# CITY OF ALBUQUERQUE

June 29, 2020

Re: **617 Madeira Drive NE**  
**Traffic Circulation Layout**  
Architect's Stamp NONE PROVIDED (K18-D108)

Based upon the information provided in your submittal received 06-26-2020, the above referenced plan cannot be approved for Building Permit until the following comments are addressed:

DIFFERENT RACK STYLE MAY BE SUBSTITUTED IF MEET THE FOLLOWING GUIDELINES

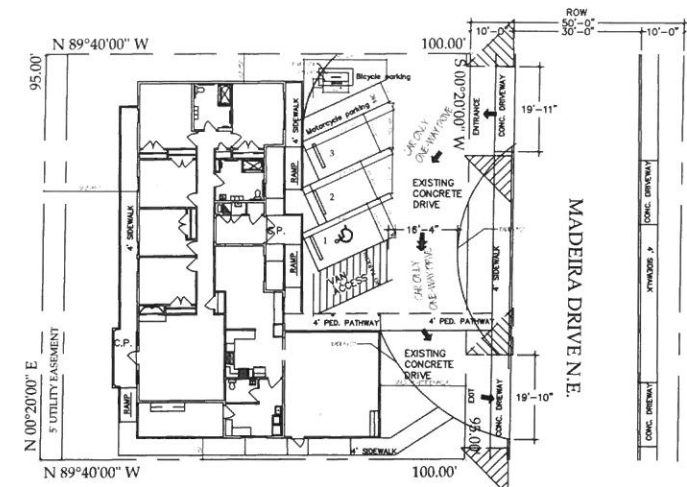
14. All bicycle racks shall be designed according to the following guidelines:
  - a. The rack shall be a minimum 30 inches tall and 18 inches wide.
  - b. The bicycle frame shall be supported horizontally at two or more places. Comb/toaster racks are not allowed.

- c. The rack shall be designed to support the bicycle in an upright position. See the IDO for additional information.
  - d. The rack allows varying bicycle frame sizes and styles to be attached.

- e. The user is not required to lift the bicycle onto the bicycle rack.
  - f. Each bicycle parking space is accessible without moving another bicycle.

15. Bicycle racks shall be sturdy and anchored to a concrete pad.
16. A 1-foot clear zone around the bicycle parking stall shall be provided.
17. Bicycle parking spaces shall be at least 6 feet long and 2 feet wide.

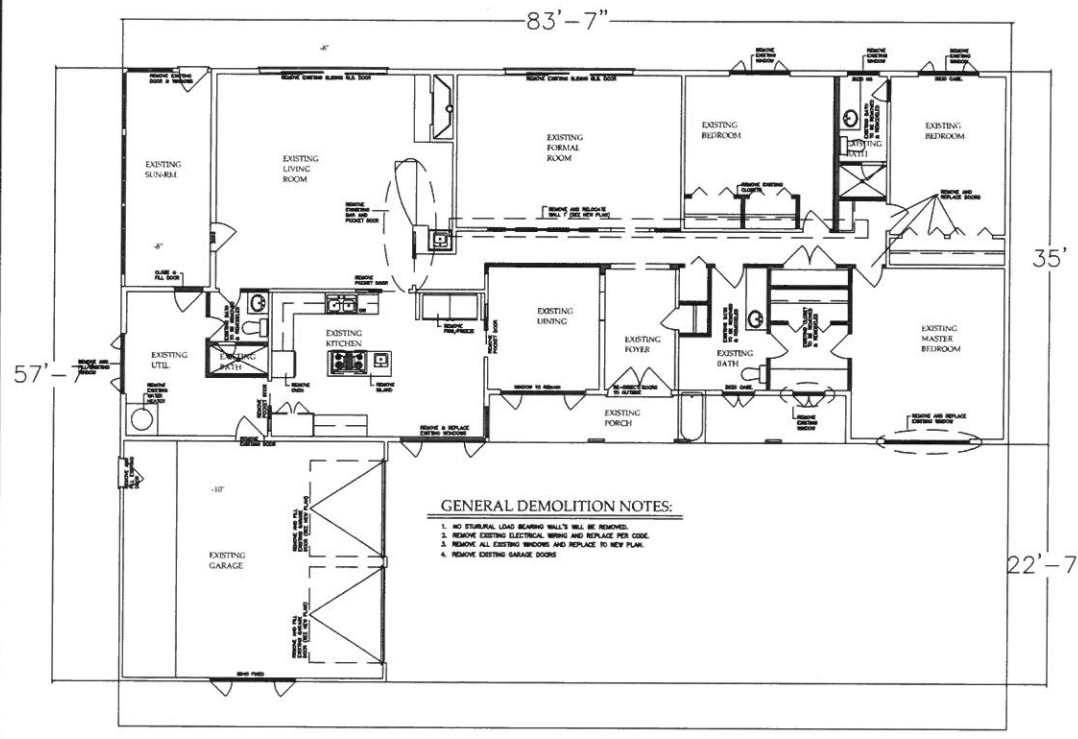
1. Please show a vicinity map showing the location of the development in relation to streets and well known landmarks.
2. Please coordinate all calculations for **parking spaces, including bicycle and motor cycle parking** with Zoning and list the number required.
3. Identify the right of way width, street widths on Madeira Drive.
4. The Traffic Circulation Layout must be stamped, signed, and dated by an Engineer or Architect licensed in the State of New Mexico.
5. Please list the width and length for all existing and proposed parking spaces. Some dimensions are not shown.
6. Dimension the existing driveways for one way circulation.
7. The minimum parking stall dimensions are for straight on parking:

8. Label the compact parking spaces by placing the words "**COMPACT**" on the pavement of each space(**if applicable**).
9. The ADA accessible spaces must include an access aisle. **Van accessible aisles should be 8ft wide**; all others should be 5ft wide.

10. The ADA accessible parking sign must have the required language per 66-7-352.4C NMSA 1978 **"Violators Are Subject to a Fine and/or Towing."** Please call out detail and location of signs.

11. The ADA access aisles shall have the words **"NO PARKING"** in capital letters, each of which shall be at least one foot high and at least two inches wide, placed at the rear of the parking space so as to be close to where an adjacent vehicle's rear tire would be placed. (66-1-4.1.B NMSA 1978)

18. Show all **drive aisle widths** and radii. Some dimensions are not shown.
19. The minimum drive aisle dimensions are shown below

20. List radii for all curves shown; for passenger vehicles. Radius for delivery trucks, fire trucks, etc. is 25 ft. or larger (**If applicable**).
21. Per the IDO, a **6 ft. wide ADA accessible pedestrian pathway** is required from the **public sidewalk** to the **building entrances**. Please clearly show this pathway and provide details.

22. Per DPM, a **6 ft. wide ADA accessible pedestrian pathway** is required from the **ADA parking stall access aisles** to the **building entrances**. Please clearly show this pathway and provide details.

24. Provide a copy of refuse approval (**If applicable**).
25. It is not apparent what type of pavement surface is being proposed. A hard driving surface will be required as part of this proposed project for parking area and drive aisles.
